PROJECT: Residential Development at Sunnyside, Yapton Road, Barnham

REPORT: 2413/TN/04/A – Technical Note to WSCC Highway Consultation Response

LPA REFERENCE: BN/73/26/OUT

DATE: August 2026

HTP Proposed Access Arrangement, ref: HTP/2413/09/D, dated 29/05/2026

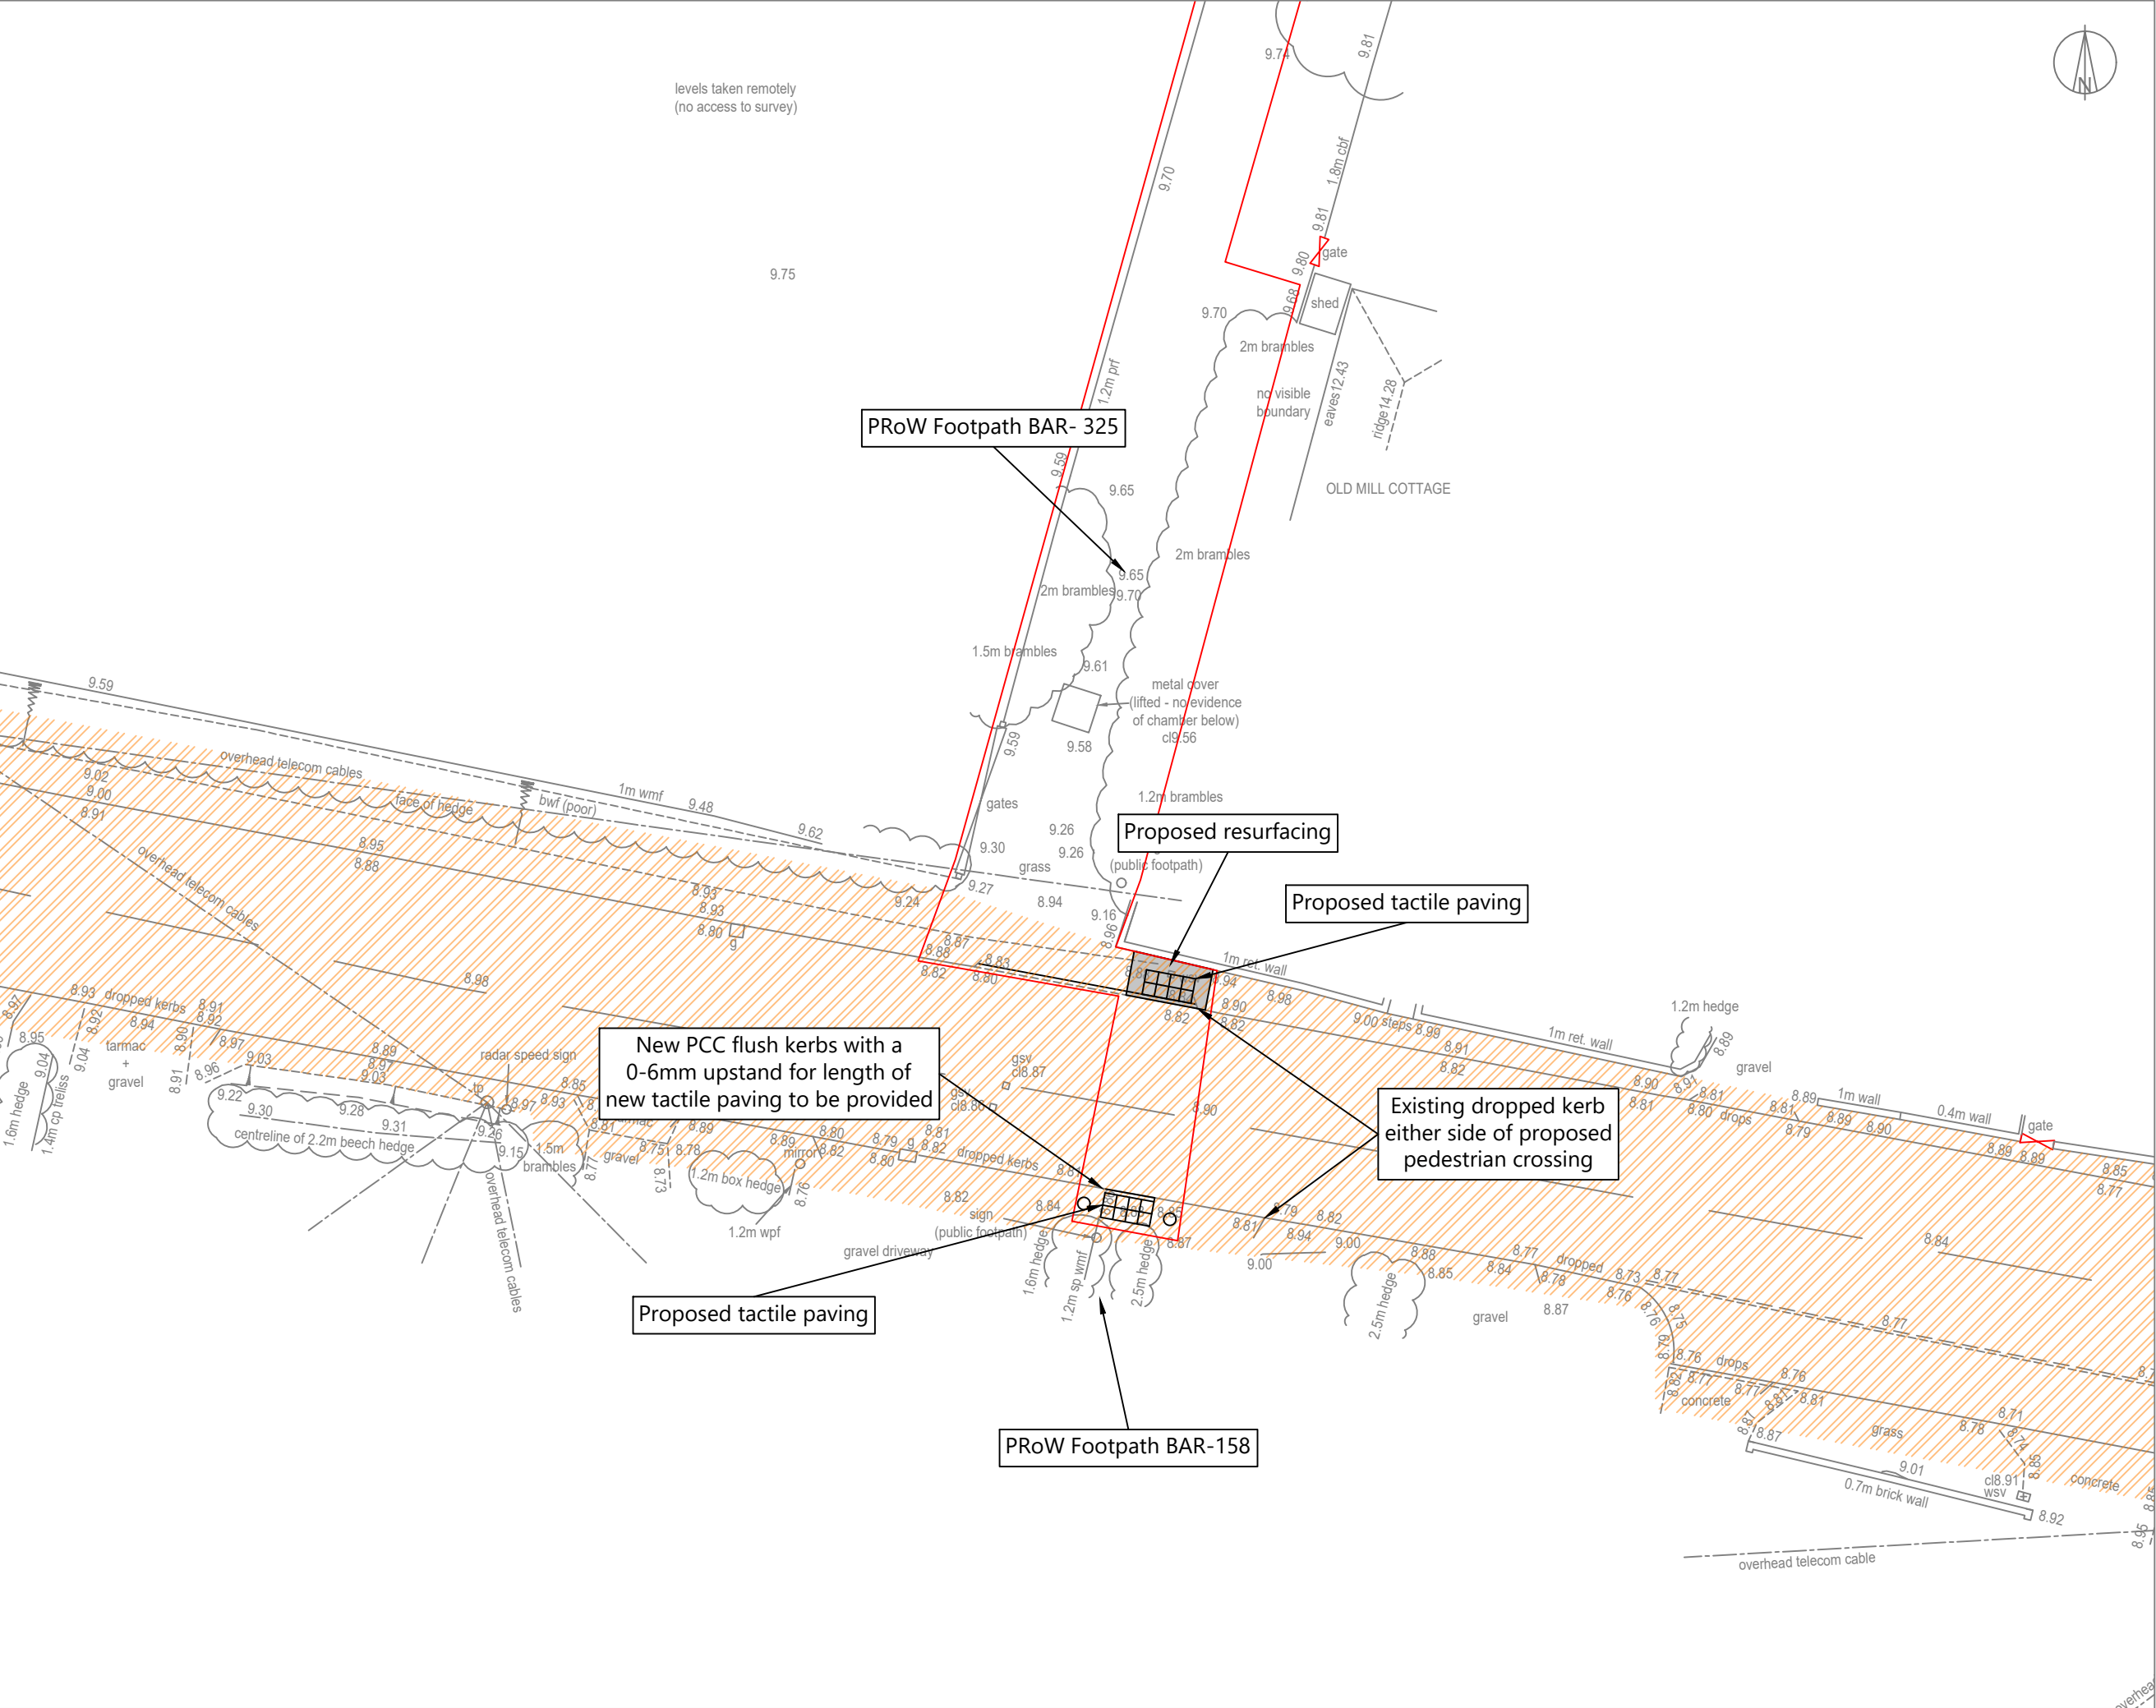
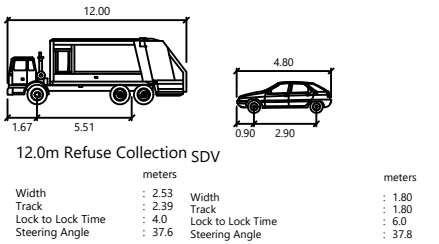
6. WSCC Highways responded, stating that after internal discussions it was considered the shared use elements should be removed from the site access. This has been done, reverting to a 2.0-metre-wide footway only, and updated plan HTP/2413/09/E (sheets 1-2 of 2) is contained at **Appendix B**, with the Road Safety Auditor comments on this revision, further to the Road Safety Audit of November 2025 (Appendix 16 of the submitted Transport Assessment HTP/2413/TA/01/A), provided at **Appendix C**.

3m wide shared use provision is provided either side of the access road and a 3m provision into the site. To the west of the site cyclists would be required to cross Yapton Road to access the shared use provision of the southern side of the road. To the east cyclists would be provided with dropped kerbs and markings to return to the carriageway. Further details should be provided as to how westbound cyclists would access the shared use provision and access the site.

7. The submitted Pedestrian and Cycle Audit (HTP/2413/TN/02/A, dated May 2026) has been reviewed in light of the changes to the site access plan, reverting from a 3.0-metre-wide shared use facility to a 2.0-metre-wide footway. The following paragraphs are impacted by this requested change to the site access:

- i. Paragraph 2.3 references that the site access proposals include for *"a shared footway/cycleway on either side of the access which will tie into the existing footway network"* – this is now a footway on either side of the access only

- ii. Paragraph 49 (1) states *"The proposed site access arrangements include the widening of this footway to 3.0 metres"* in relation to the observation that the existing footway on the north side of Yapton Road adjacent to the site is very narrow – the footway is now agreed to be widened to 2.0 metres, as it is no longer a shared use facility. This is acceptable based on Manual for Streets standards

Figure 5.2 – Proposed tactile paving on Yapton Road

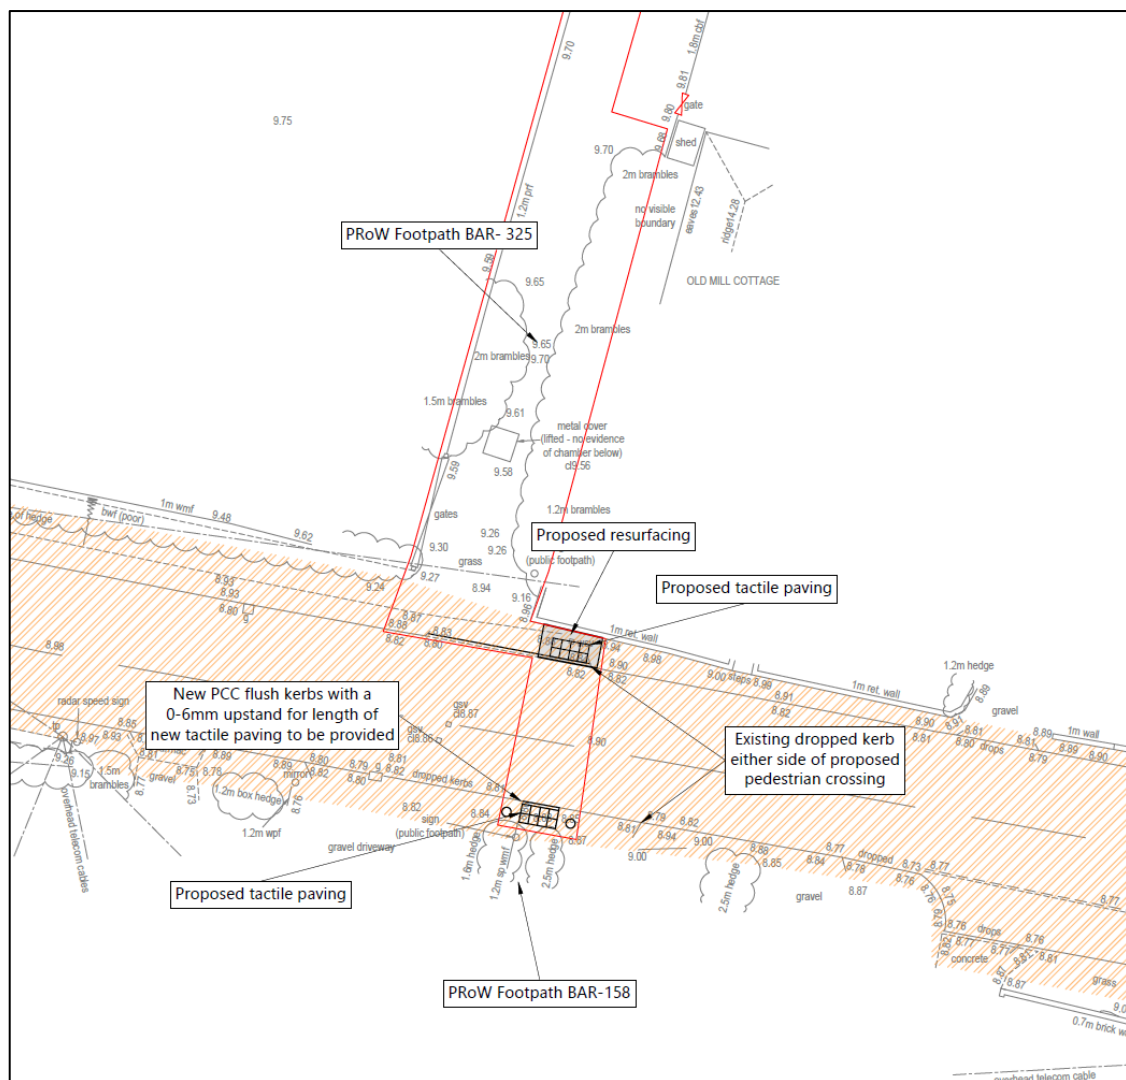
It is proposed to surface the section of PROW 325 within the site boundary. Further information should be provided to detail the points in which the footpath provision would connect back into the PROW. A contribution should also be provided for upgrading the surface of the PROW outside the site boundary.

16. This application is in outline. As such, the plan HTp/2413/15 provided at **Appendix F** in response to the WSCC request to show the points at which the footpath provision will connect into the PRoW Footpath 325 is for illustrative purposes only, using the DLA Illustrative Masterplan.
17. Two indicative locations are shown where the site footpath connections would connect to Footpath 325 (see **Figure 2**). It is considered that this plan can be conditioned.

18. The connections are currently proposed to be open (not gated), but the final decision on this will be made at Reserved Matters.
19. Around 50% of Footpath 325 falls within the site boundary. As shown indicatively on **Figure 3** (blue line), which uses the DLA Landuse Parameter Plan (DLA.2242.L.26.P02) as a base.

20. At this stage, given the Network Rail temporary closure on this stretch of Footpath 325, and likelihood of full closure in the future, it is considered that the only section of the footpath to be upgraded is the section that falls within the site boundary. The surfacing will be to WSCC specification and agreed at Reserved Matters.
